HIA Addendum

In July 2021 a Heritage Impact Assessment (HIA) report was completed as part of a Development Application (DA) submission package for a proposed Reptile & Amphibian Conservation Centre development at Taronga Zoo on behalf of the Taronga Conservation Society Australia (TCSA). Following further reviews by the TCSA, various (external and internal) architectural planning and design revisions have been made to the proposed schematic design by the architects (**dwp**). As a result of the external changes, some qualification has been required for the earlier heritage impact report.

Project Number  
**RACC 20-0527**  
 Drawing Number  
**AA7000**  
 Issue  
**E**

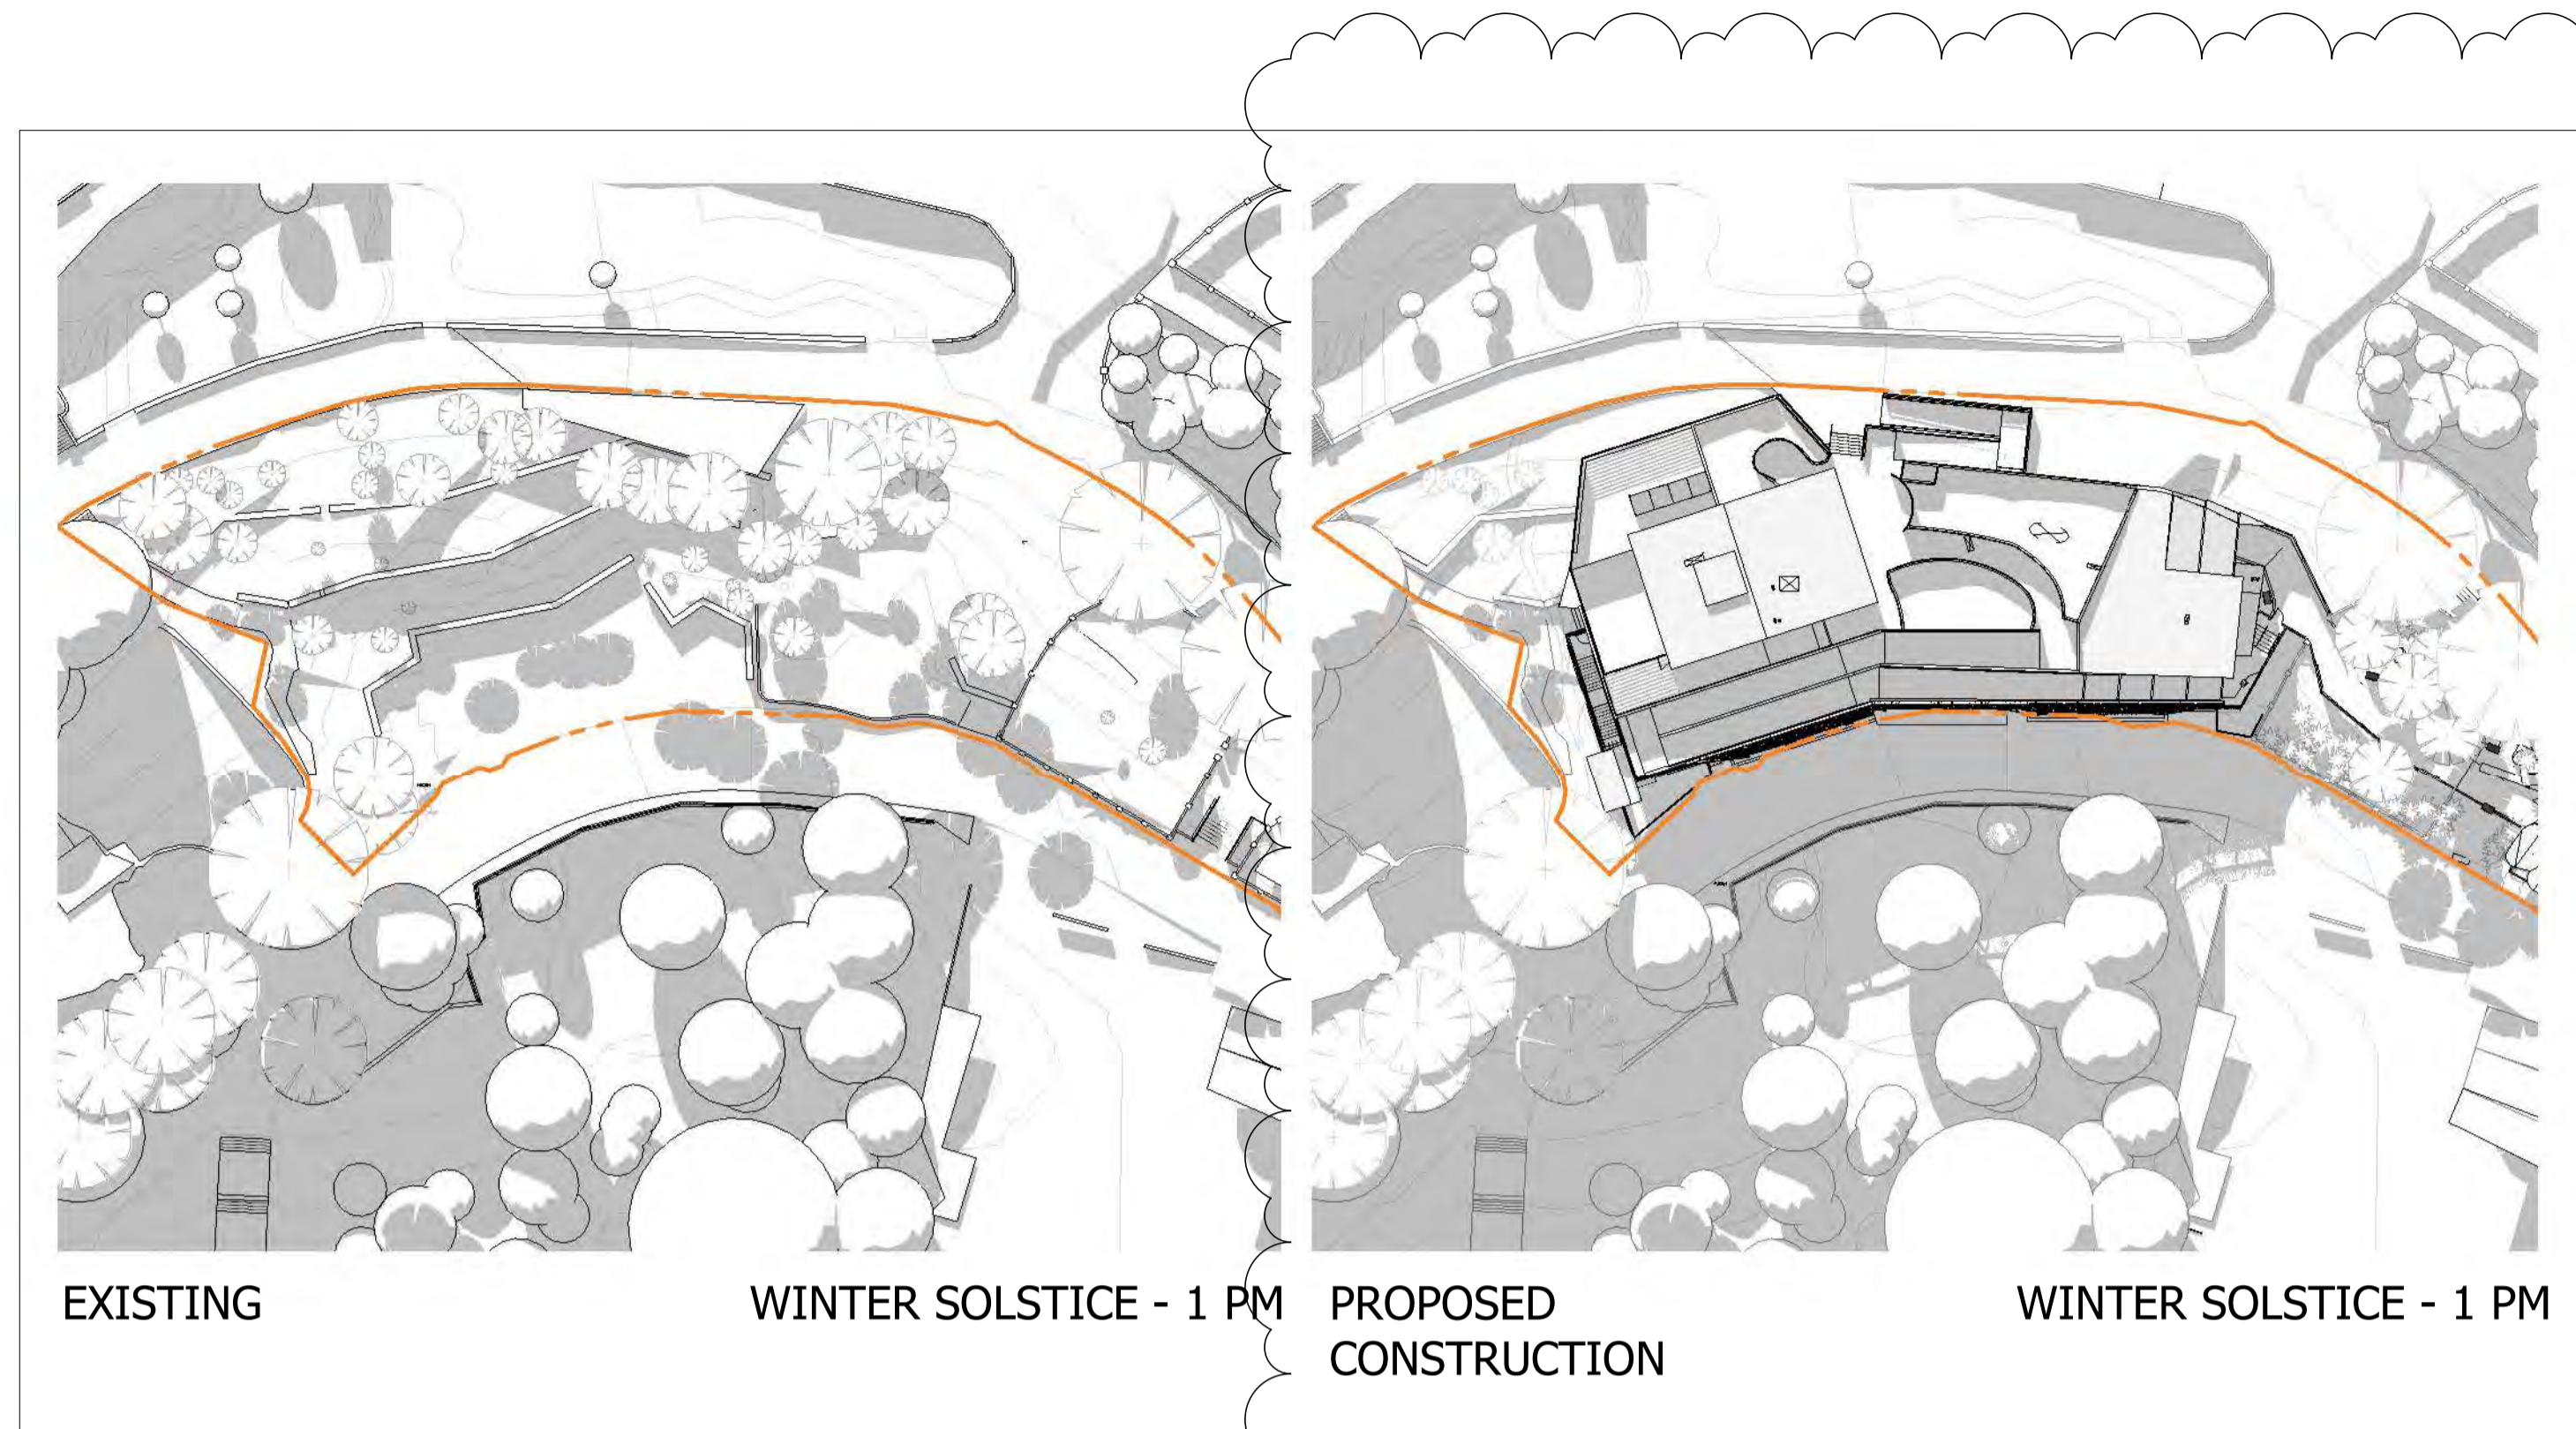
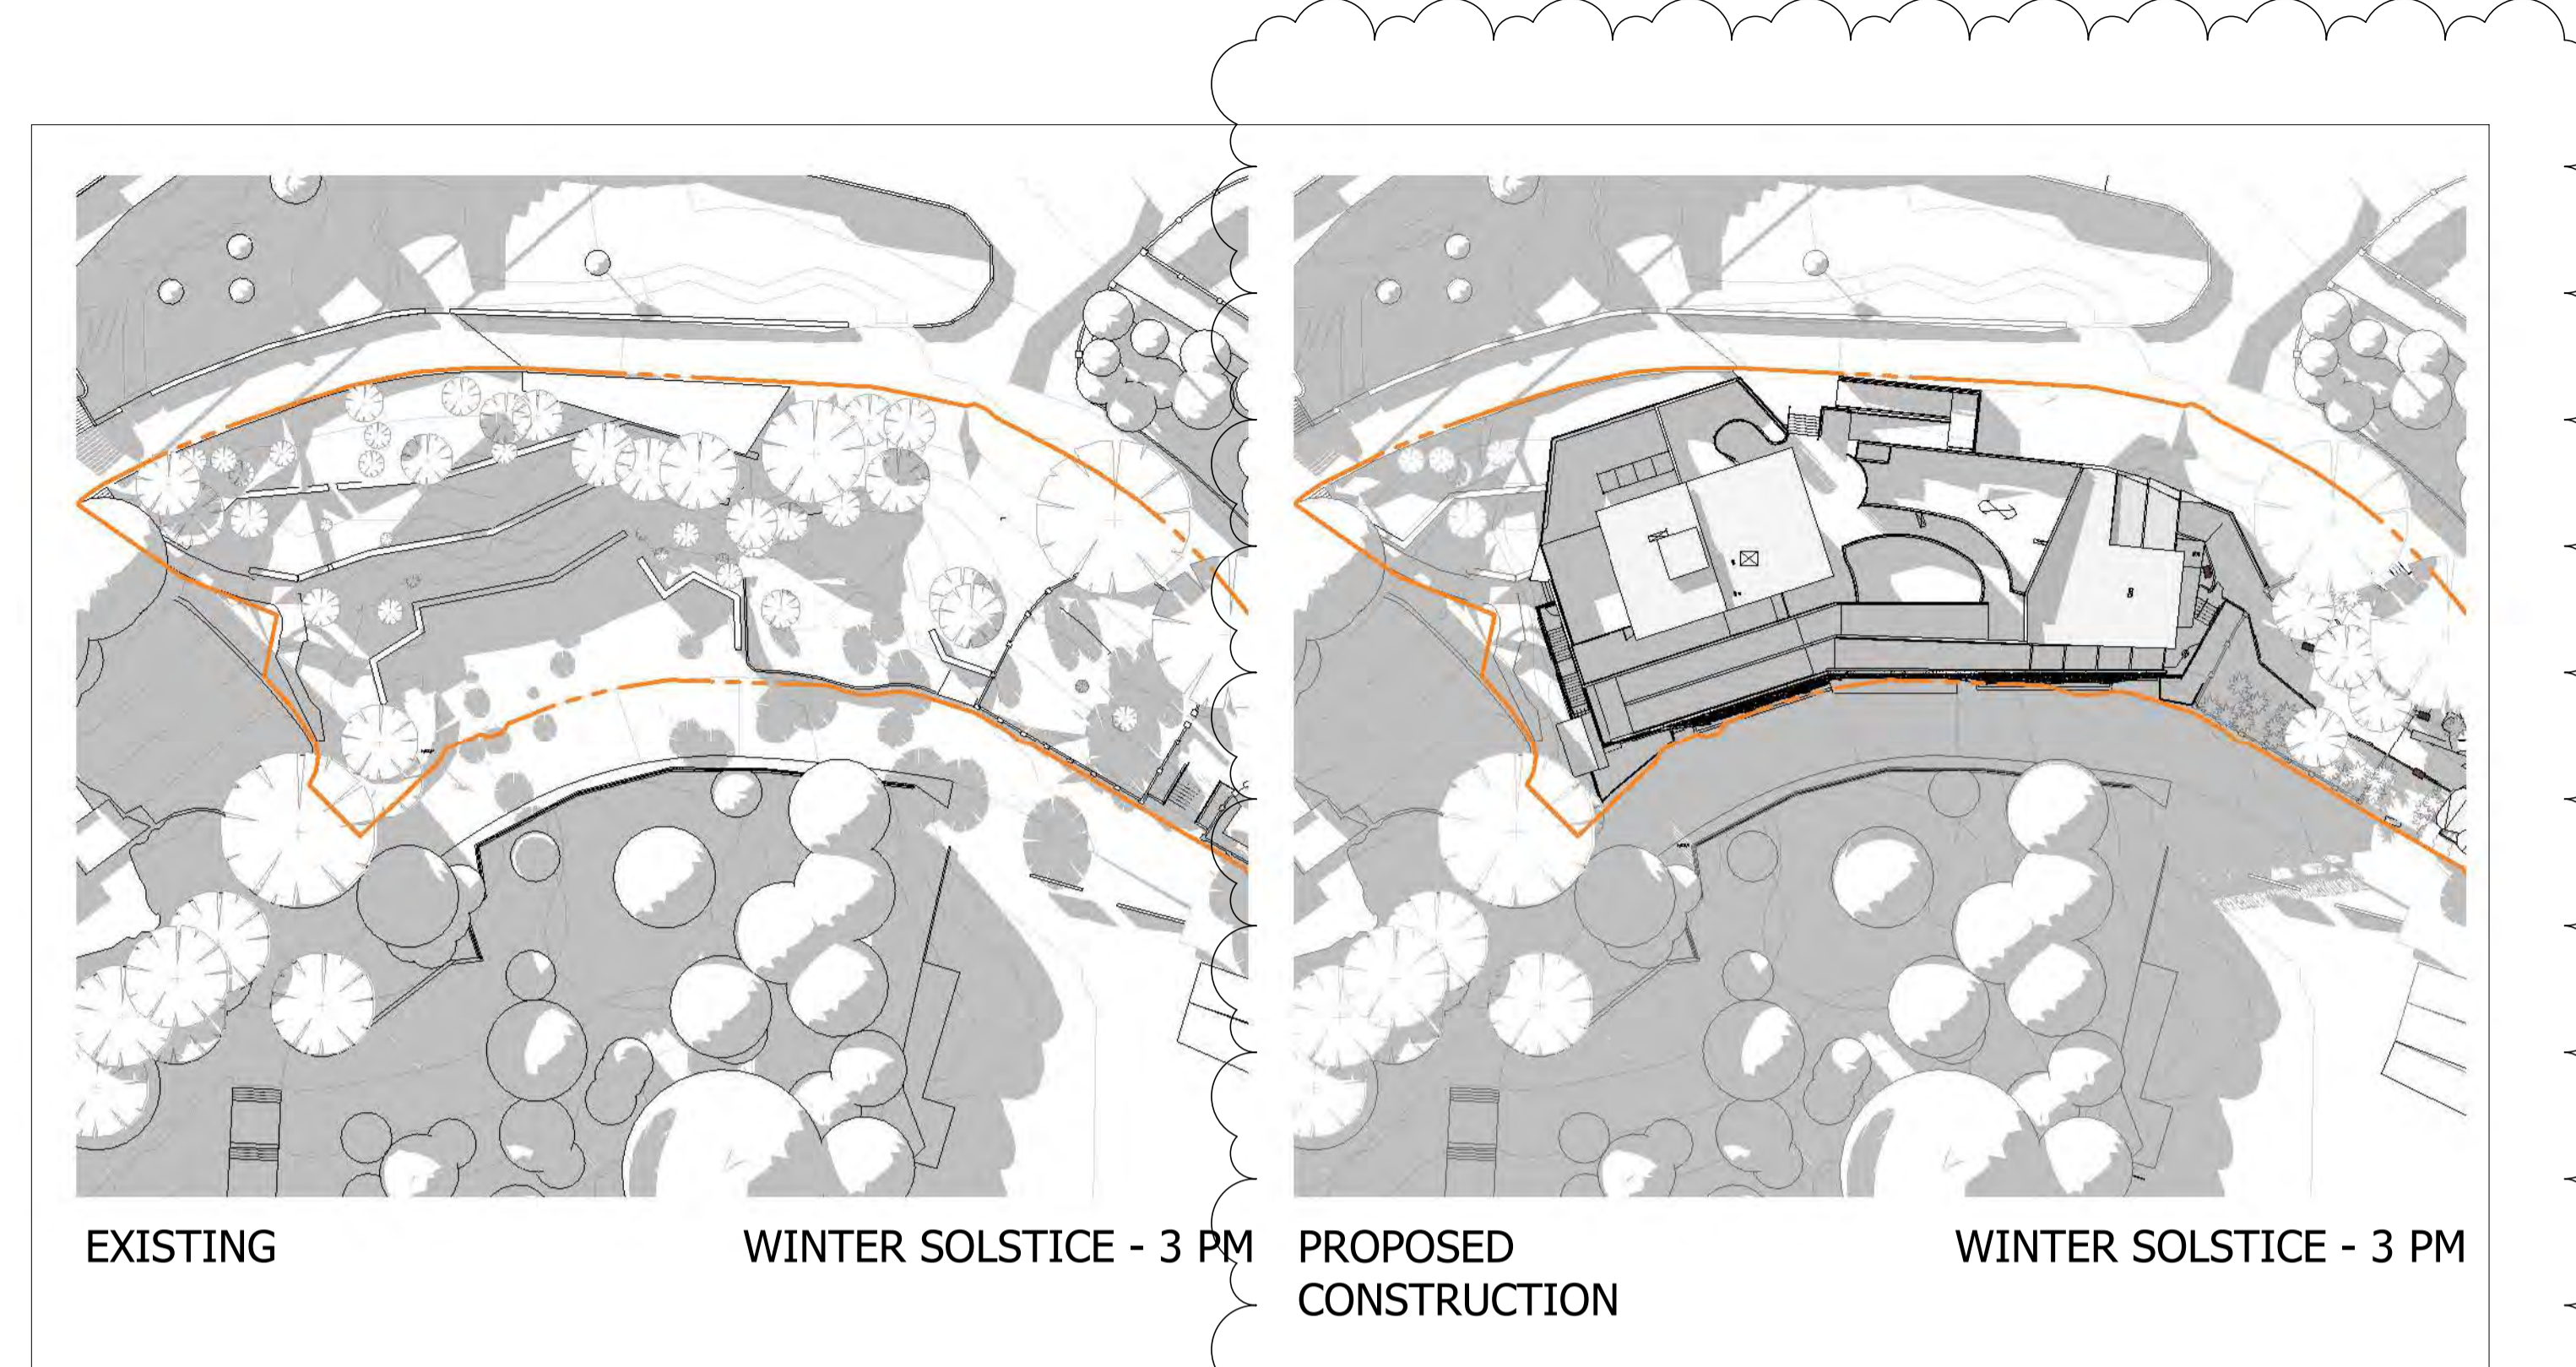
- * Exhibit area to the south would result in less shadowing/shade through the winter months albeit there would still be slightly more than at present.
